Rezoning Transportation Analysis

Petition Number: 2023-041

Date	Description
7-26-23	First Review (PDM)

The petition is located at the intersection of Brevard Street, a City-maintained major arterial and Fourth Street, a City-maintained major arterial. The petition is located in an Uptown Center City Activity Center inside of Route 4, within the Brevard Street Urban Design Study.

SHEET NUMBER  
**RZ-01**

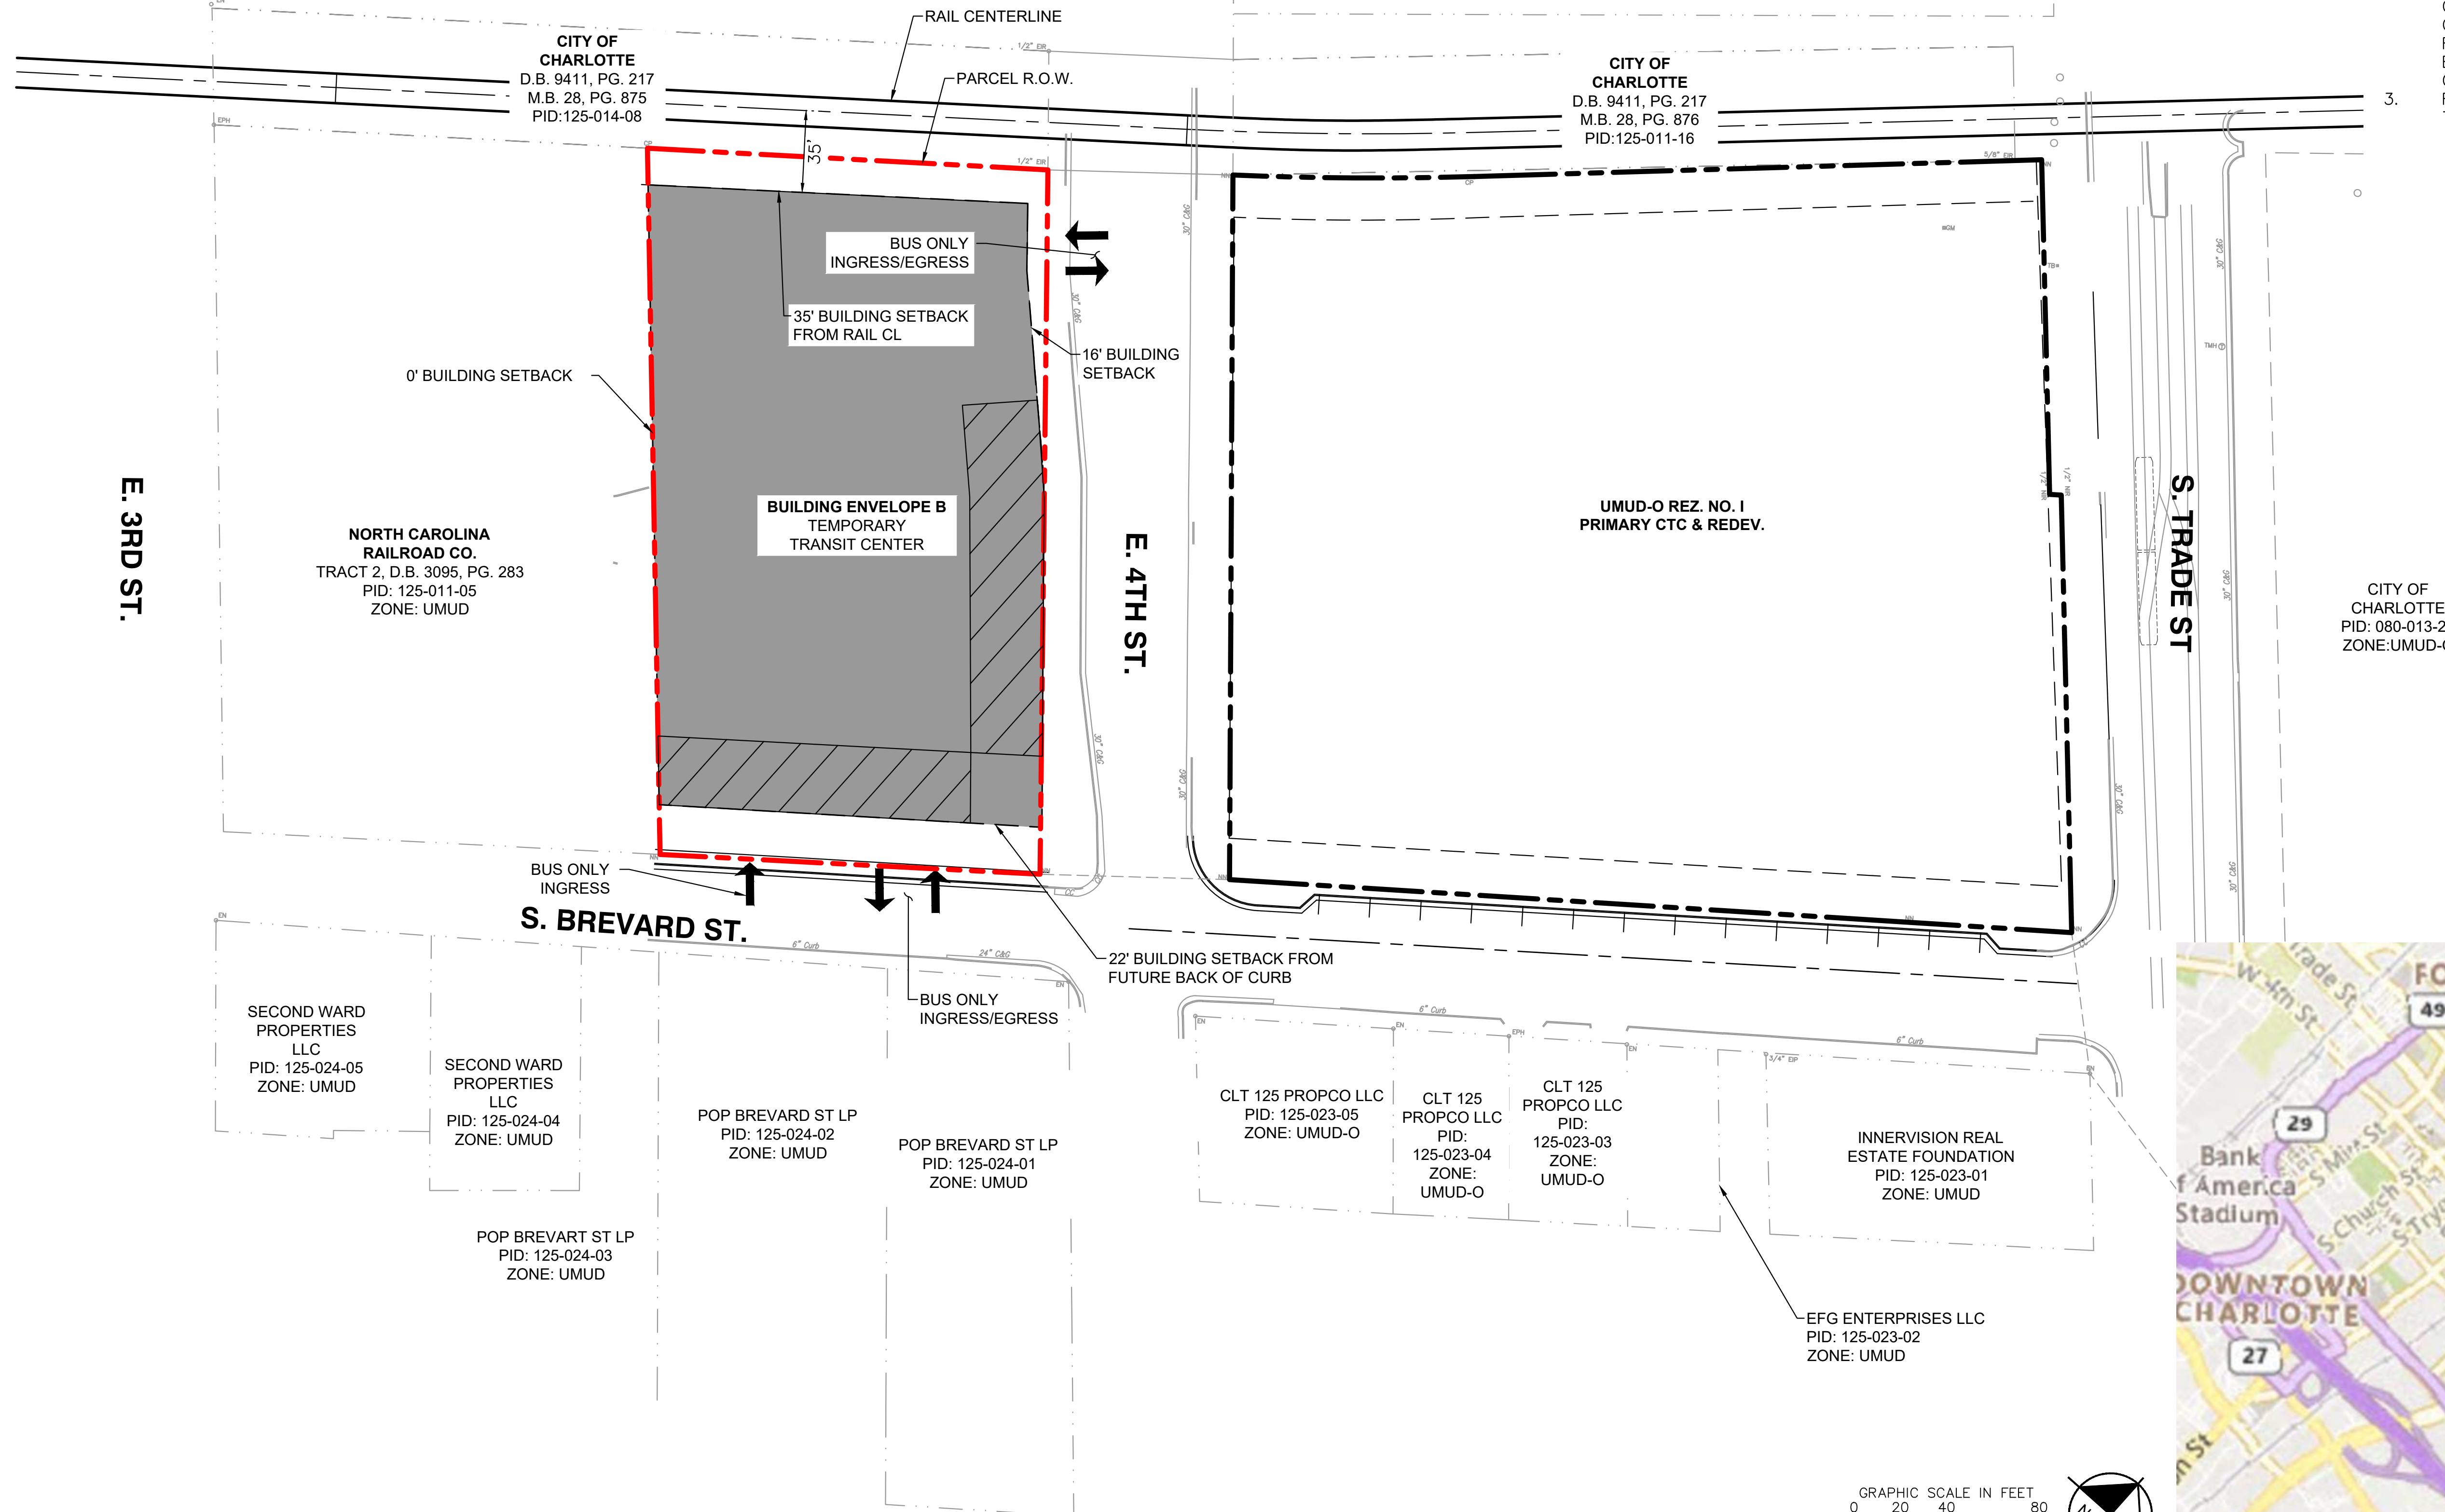
Label and dimension the curb and gutter from the centerline for each road on the site plan.

- 4. Revise site plan and conditional note(s) to commit to dedicate a minimum of 40 feet of right-of-way from the road centerlines of Brevard Street and 4th Street if it does not exist today. The site plan shall label and dimension the right-of-way from the road centerline.
- 5. Revise site plan and conditional note(s) to commit to construct bicycle facilities by installing a multi-use path on Brevard Street and 4th Street to meet the Council-adopted Charlotte BIKES Policy. Multi-use paths maintained by the City shall meet ADA/PROWAG requirements.
- 6. Revise site plan and conditional note(s) to commit to provide the streetscape for Uptown Signature Streets on Brevard Street and the streetscape for Uptown Primary Streets on 4th Street.

7. Revise site plan and conditional notes to provide a 12ft rail trail along the Blue Line and provide a connection to the Rail Trail to the site. Design must accommodate bicycle operations.
